Your Ref: OWPC19719
Our Ref: LU/192/18/PL
Please ask for:
Mrs A Gardner

External alterations to south & west elevations comprising of removal of external doors, replacing pair of doors with roller shutter & new horizontal cladding.

Enterprise Unit 1-5 Harwood Road Littlehampton

DRAWING TITLE
PROPOSED PART FLOOR PLAN
AND ELEVATIONS

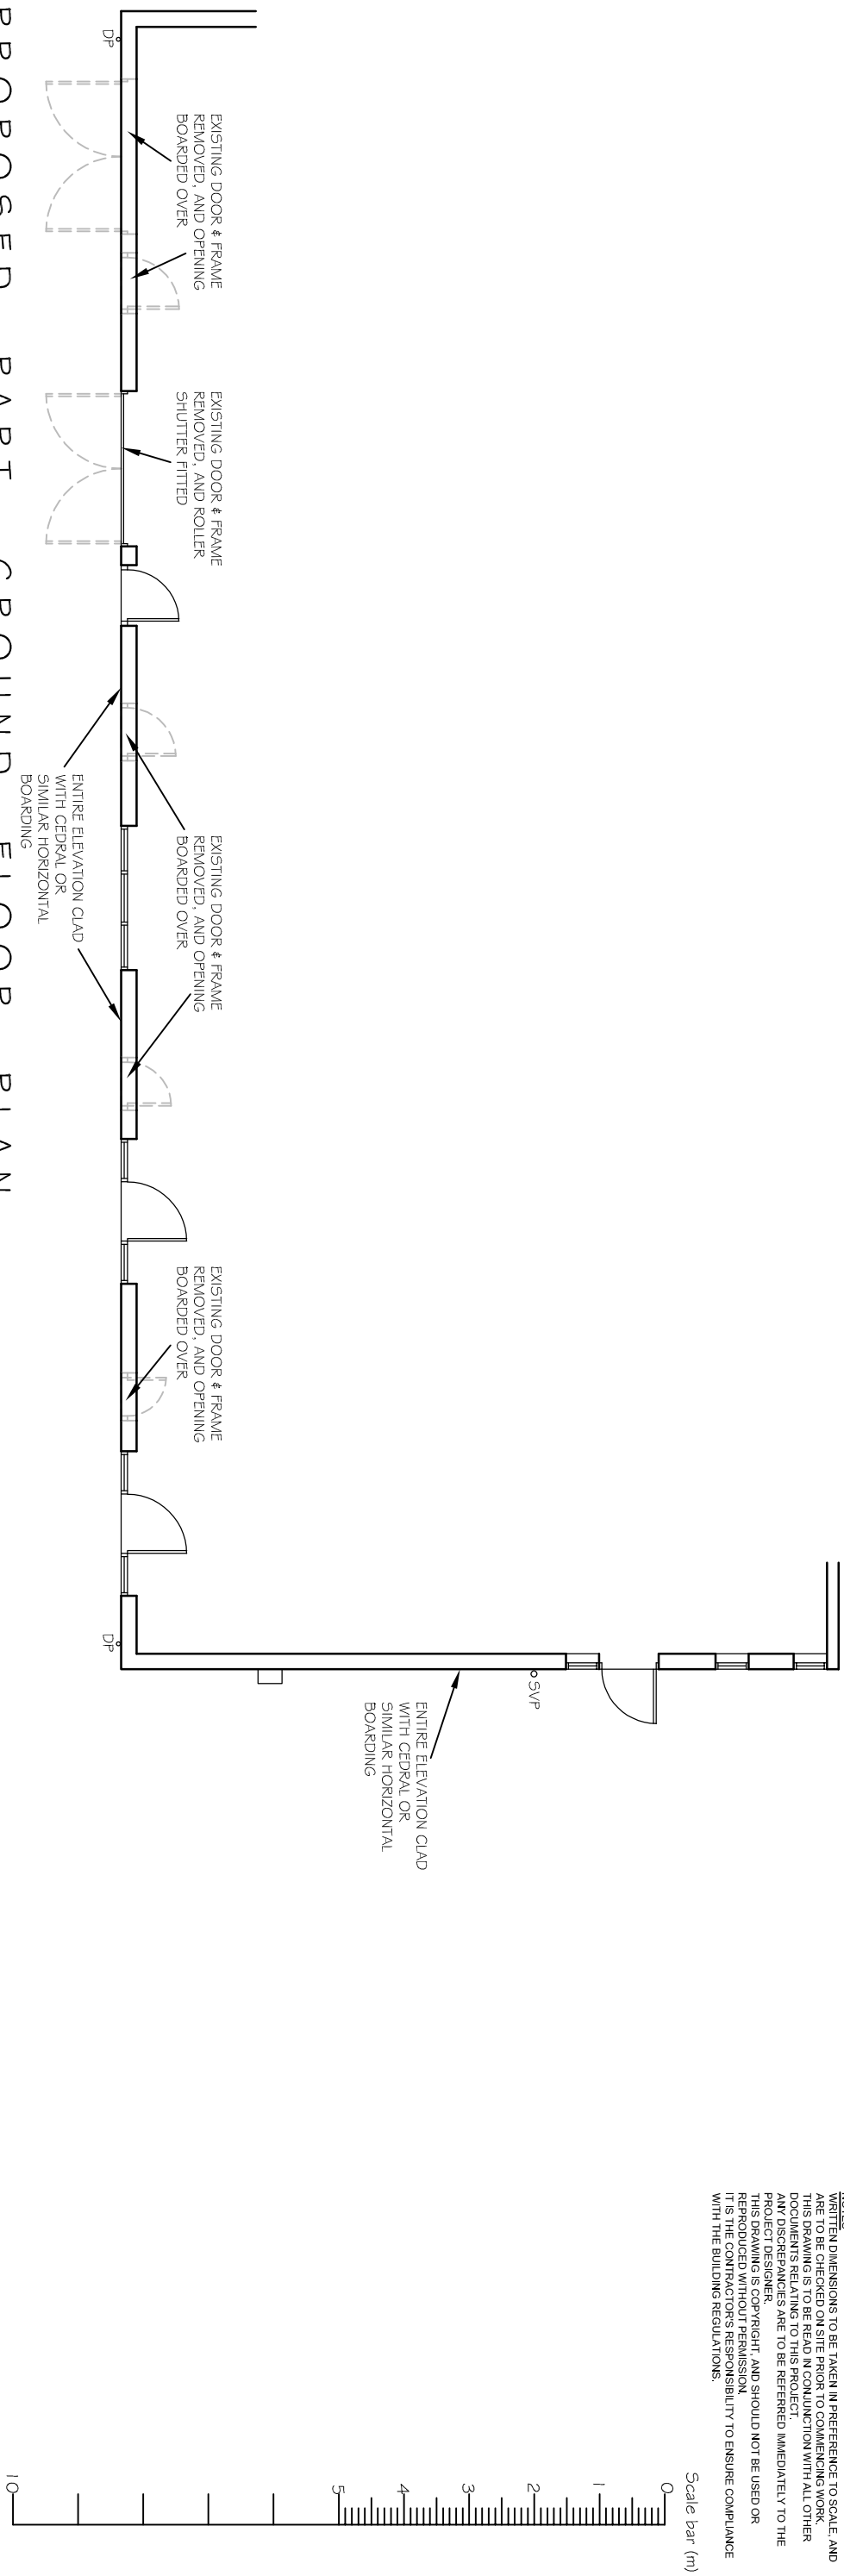
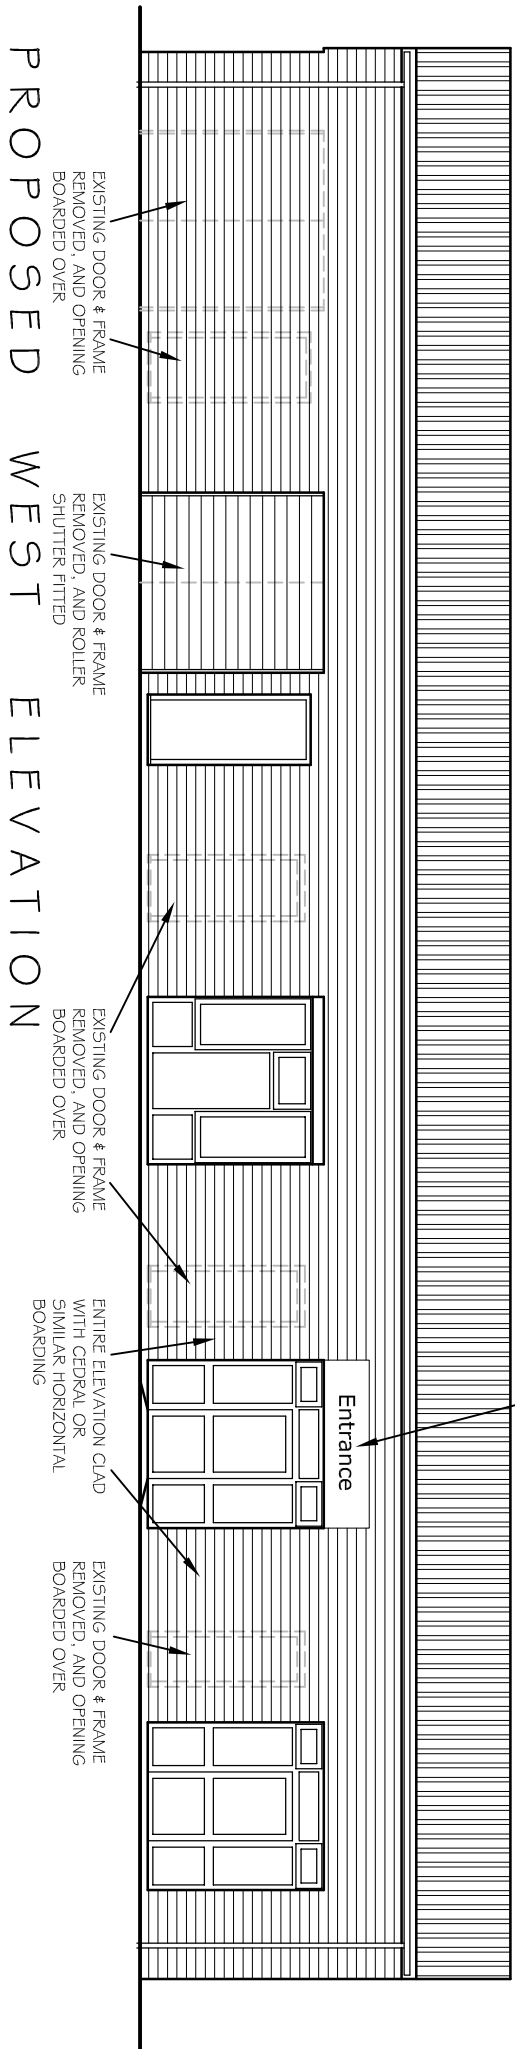
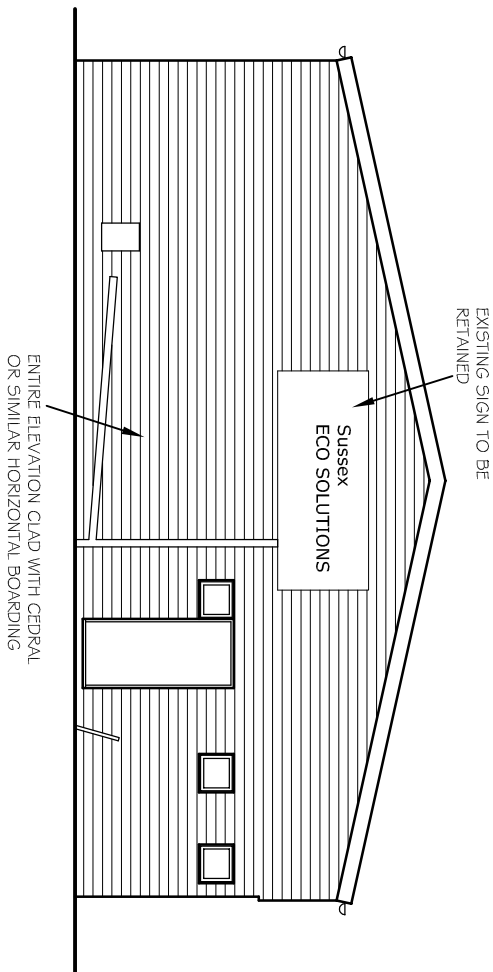
The Town Council's Planning and Transportation Committee considered this matter at its meeting held on Monday 20th August 2018 and had no objection to the application. Observing the proximity of the unit to a residential area, it was commented that the use of roller shutters can be noisy and could cause a disturbance if used in anti-social hours. Members therefore ask that the LPA to take this into consideration when assessing the impact of application on the amenity of neighbouring residential properties.
